From: Amanda Scholes on behalf of Planning.Responses
Sent: 18 August 2020 11:01
To: Planning Scanning
Subject: FW: Discharge of Condition application A-86-20-DOC - Manor Nursery, High Street, Angmering

Please could you confirm you are satisfied with the following wording and that no plans or documentation have been missed off the draft decision letter for **Condition 20** of discharge of condition application **A/86/20/DOC**.

Southern Water Plan Number 034392

DRAWN	DATE	PROJECT NO.
N Shields	July 2019	22995
ENGINEER	CHECKED	DRG. NO.
S Burgess		110
SCALE		A
1:250 @ A1

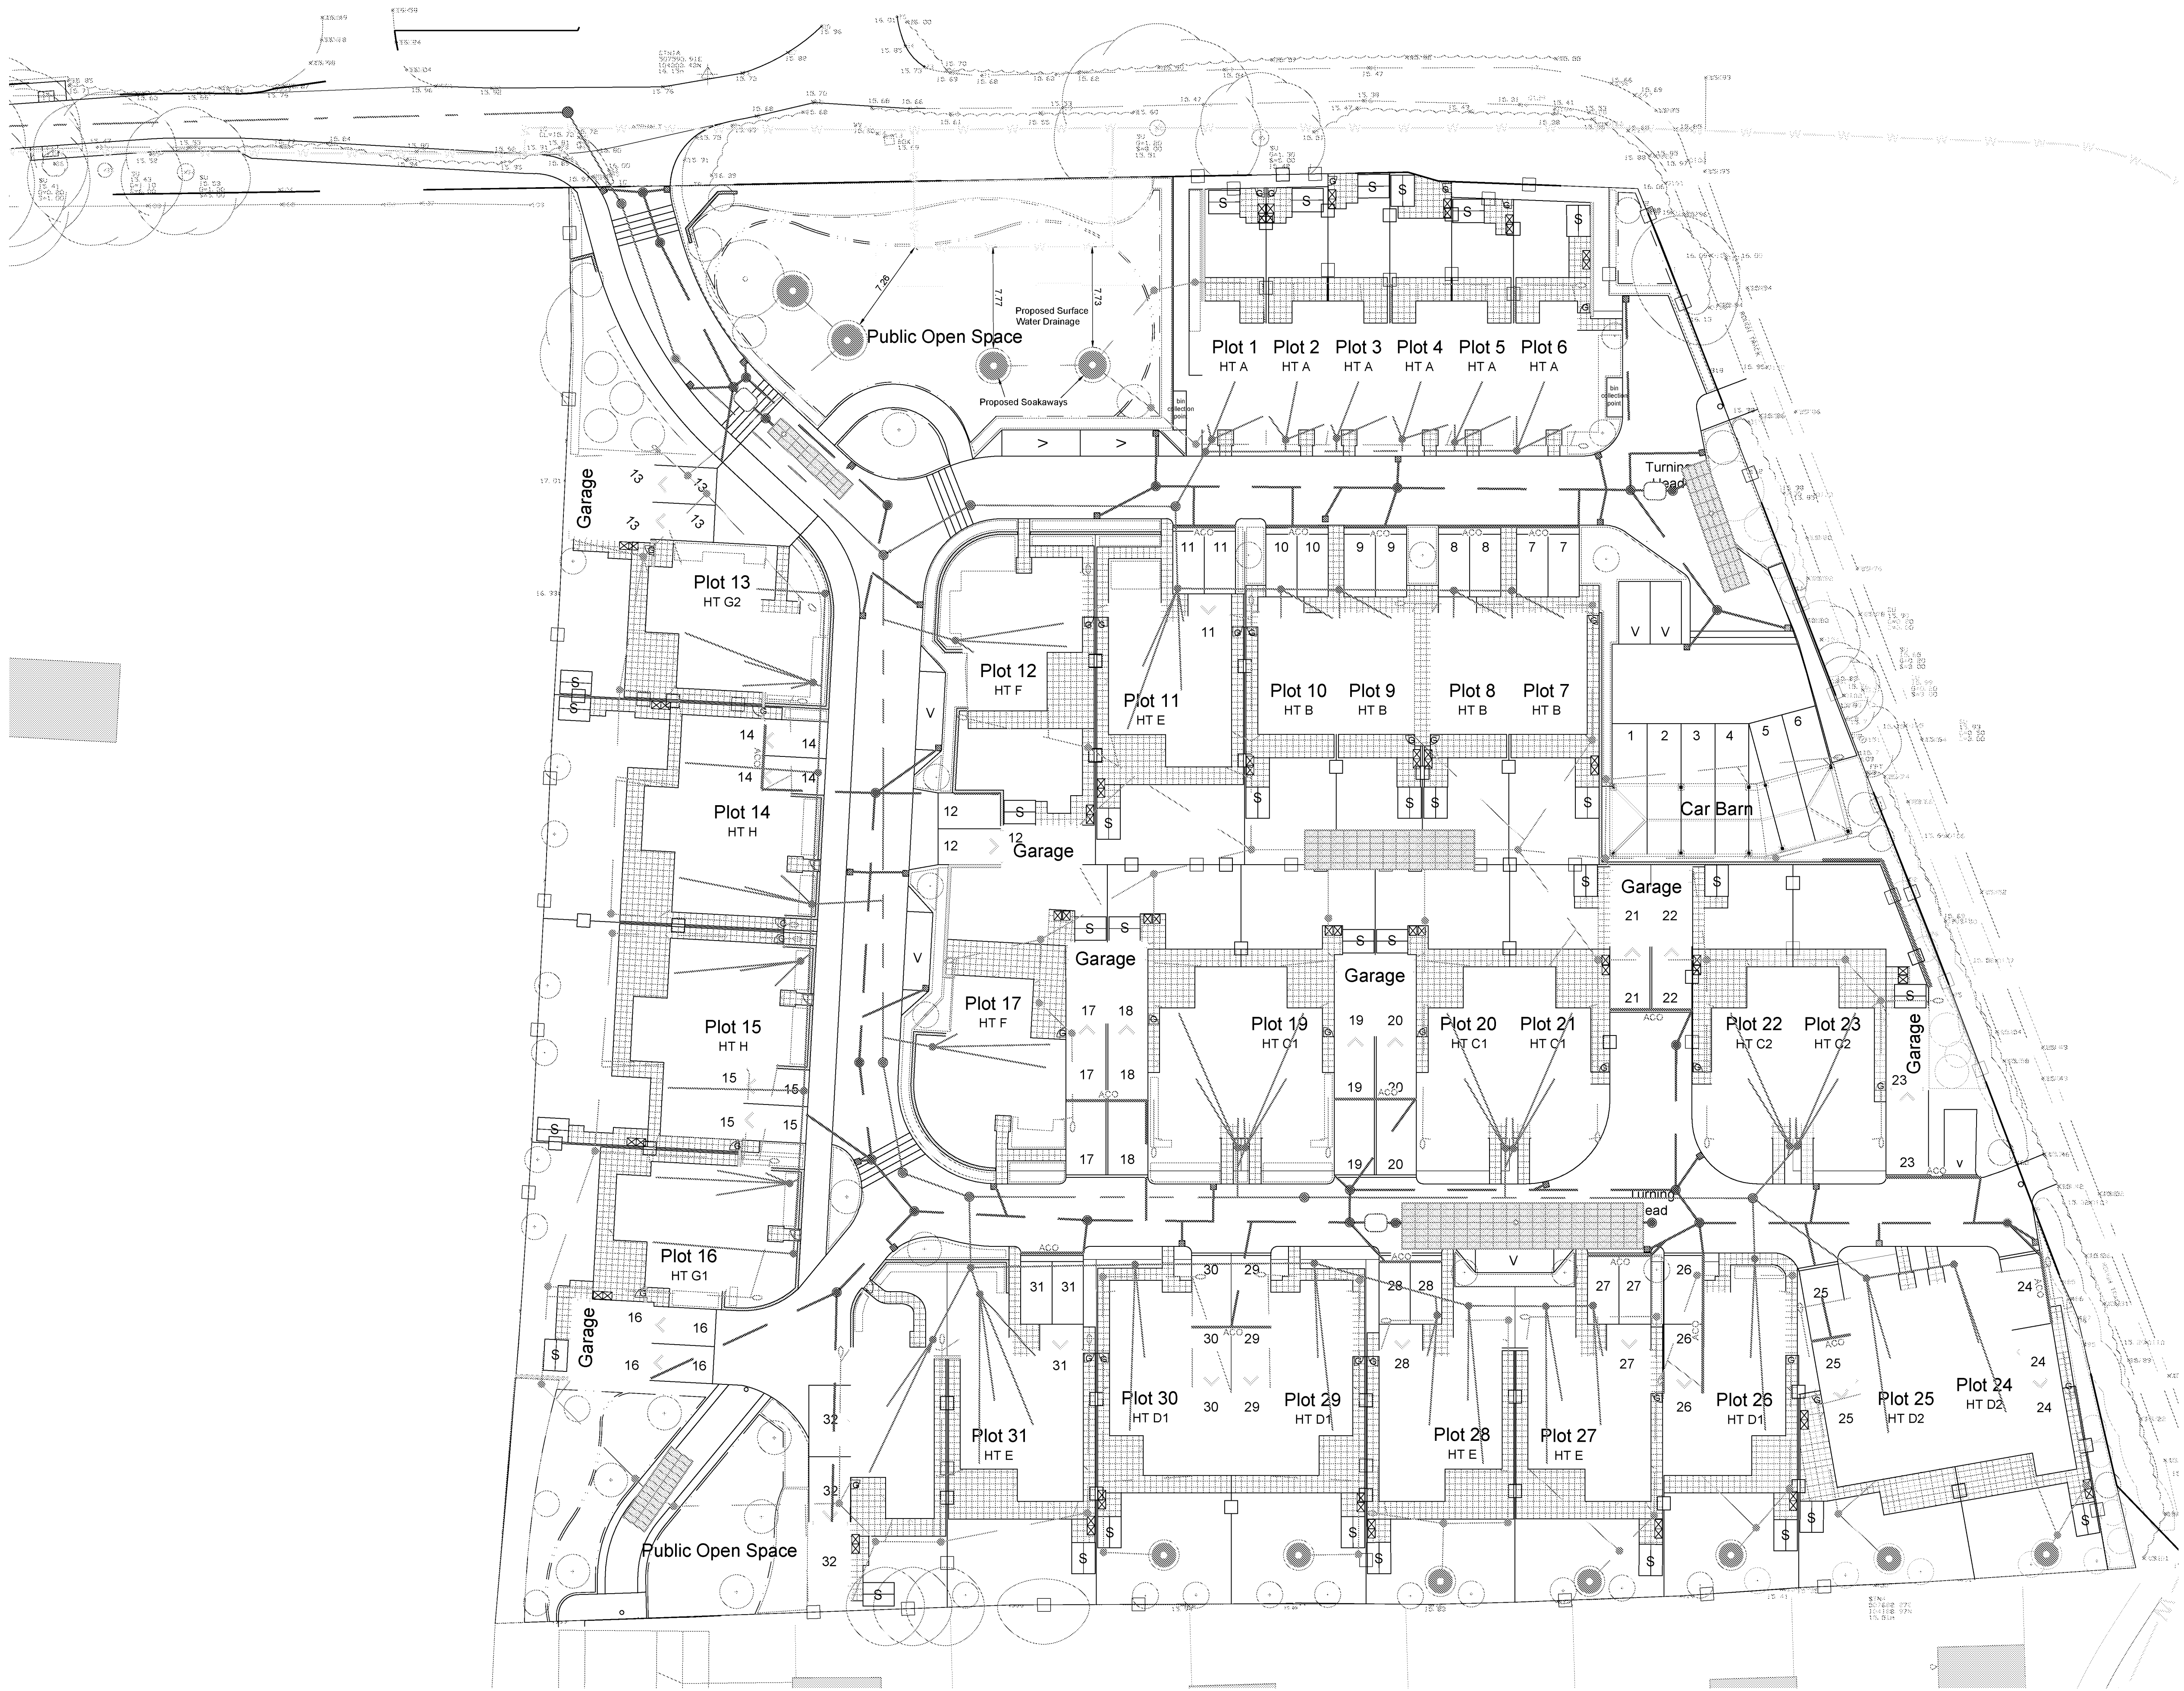
The water main is indicated as 80mm in diameter on Southern Waters asset plan (plots pdf.pdf, copy attached) it will be located in public open space on completion of the development and we have noted a 3m easement and no construction zone to protect the asset during construction.

We do not believe a formal easement is required for this water main as it does not meet Southern Water's criteria requiring an easement. I have attached Southern Water's published guidance which notes that sewer/water mains in public highway or public open space do not require easements, neither do water mains with diameters smaller than 300mm or less than 3m in depth all of which apply to this 80mm diameter water main.

We have indicated a 3m easement and no construction zone to ensure protection during construction and have noted both in the attached email to Southern Water dated 23 July 2020, from my colleague Steve Burgess, to which we have yet to receive a response.

We have attached plan 110A which details the dimensions to the soakaways from the water main at 7.26m, 7.77m and 7.73m. Southern Water's published stand off distances to soakaways for a water main of less than 250mm diameter and less than 3.5m deep is 6m. The Southern Water letter notes that No Soakaways...should be located within 5m of public water main. The soakaways, at a distance greater than 7m from the water main, are not within the 5m requested or the 6m standoff distance for this size of water main.

Basically, Southern Water requires a **6m easement**.

Sorry for the delay in replying, if you could please quote our PLAN number in future correspondence this will speed things up for us (034392). In such instances Southern Water requires a 6m easement and therefore cannot approve the discharge of condition 20.

This has clarified the situation for me and I can confirm condition 20 can be discharged.

Southern Water's comments are noted with regard to the proposed soakaways being situated too close to the main in their current position therefore these have been relocated to provide a minimum offset of 5m from the main, as requested. Please refer to the attached amended plan which shows the soakaways positions in relation to the water main along with the previously proposed (3m) easement area.
